Our Ref: - 1926 – North Bierly – Letter to EA

Planning Ref: 2021/94208

2nd March 2022

OUTLINE APPLICATION FOR RE-DEVELOPMENT OF FORMER WASTEWATER TREATMENT WORKS, INCLUDING DEMOLITION OF EXISTING STRUCTURES TO PROVIDE EMPLOYMENT USES (USE CLASSES E(G)(II); E(G)(III); B2 AND B8). FORMER NORTH BIERLEY WASTEWATER TREATMENT WORKS, CLIFF HOLLINS LANE, OAKENSHAW, BD12 7ET

SITE CONSTRAINTS

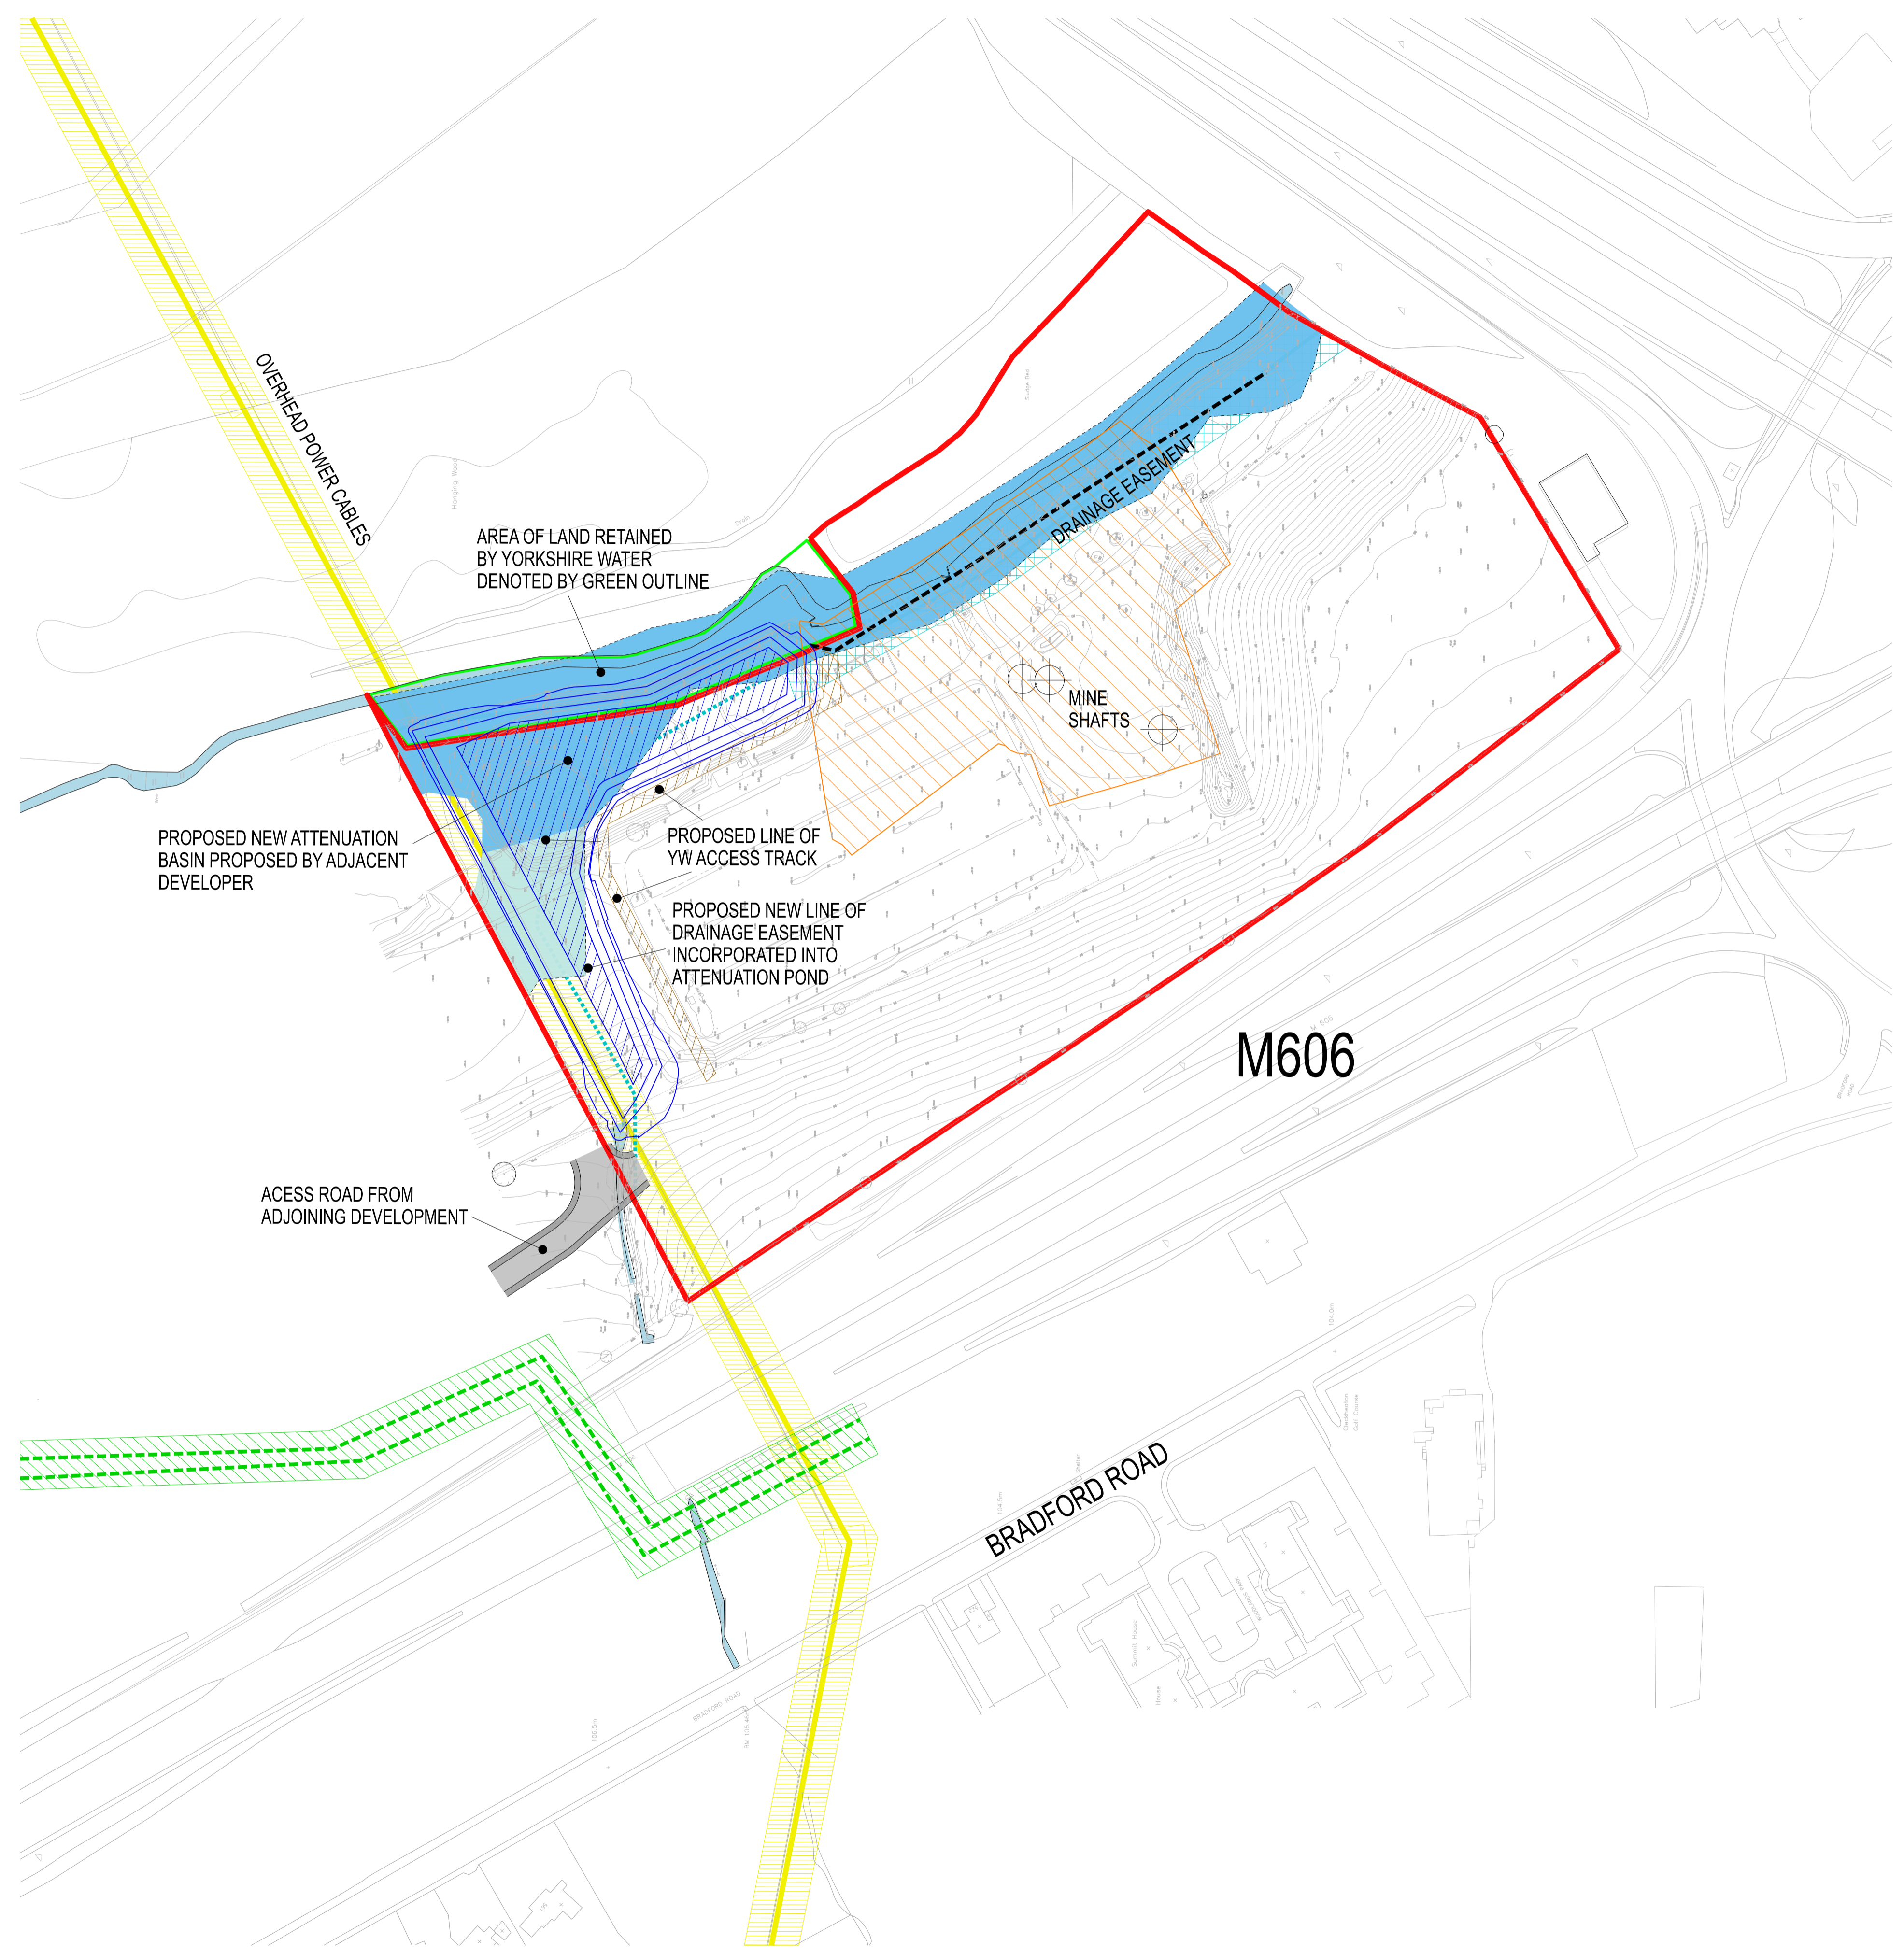
- 1) The majority of the site lies in Flood Zone 1, however, there is an area of Flood Zones 2 and 3 within the red line boundary and close to the development.**

Attached to this letter is Civic Engineers' drawing 1926-CIV-XX-XX-GA-C-00001 (Appendix A) which presents the proposed development overlaid with the current flood zone 3 extents. This drawing confirms that the flood zone 3 extents protrude into the site's redline boundary, however the proposed development sits outside of the extents.
